From: Mat Holland [REDACTED]
Sent: 23 June 2011 18:30
To: Janice Chapman
Subject: [Mailwall-Spam:]re: p/37/11 - rear storage building and car port at 64 st

Subject: [Mailwall-Spam:]re: p/37/11 - rear storage building and car port at 64 st , Pagham
Date: Thu, 23 Jun 2011 15:42:38 +0100
From: [REDACTED]
To: [REDACTED]

Title : Proposed South & East Elevations
Address : 64 St Thomas Drive, Pagham.
Date : 05,04,11
Scale : 1:100
Dng.No : PE06

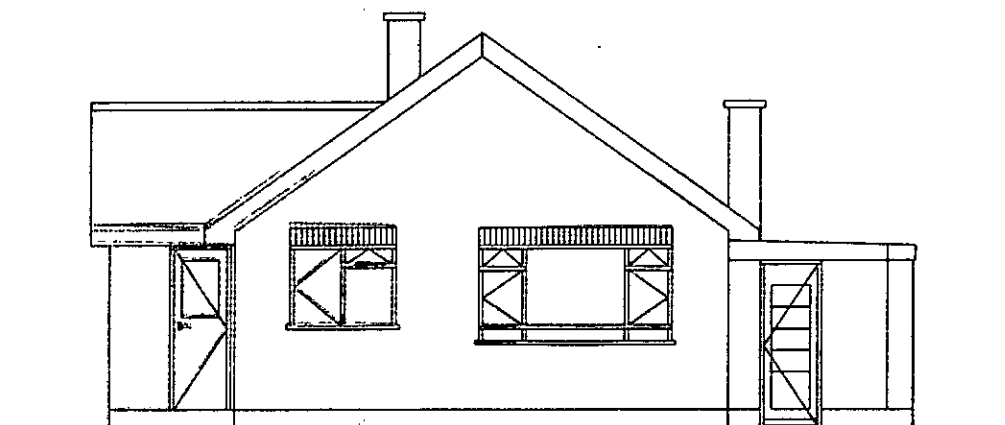
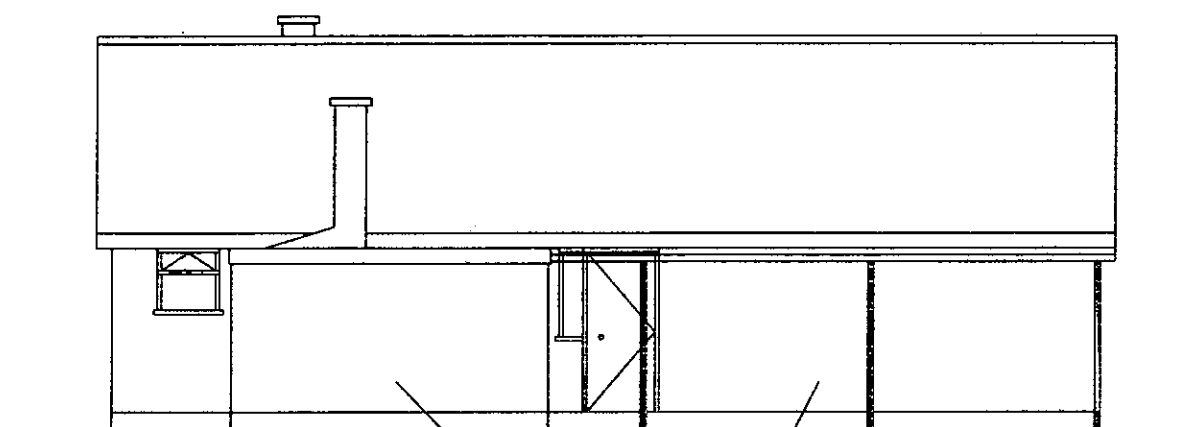
Please confirm that the car port will not extend beyond the front wall of the bungalow. Will the car port and store have green mineral roof and the car port being open on two sides will be supported by what, please confirm type of support.

Dear Mrs Chapman,
Thankyou for your email.
The proposed car port does not extend beyond the front wall.
The store roof covering green mineral finish, car port roof to be poly-carbonate translucent.
Car port to be supported by the boundary fence posts or 70mm diameter metal poles sleeved by plastic.
Many thanks
Mat Holland
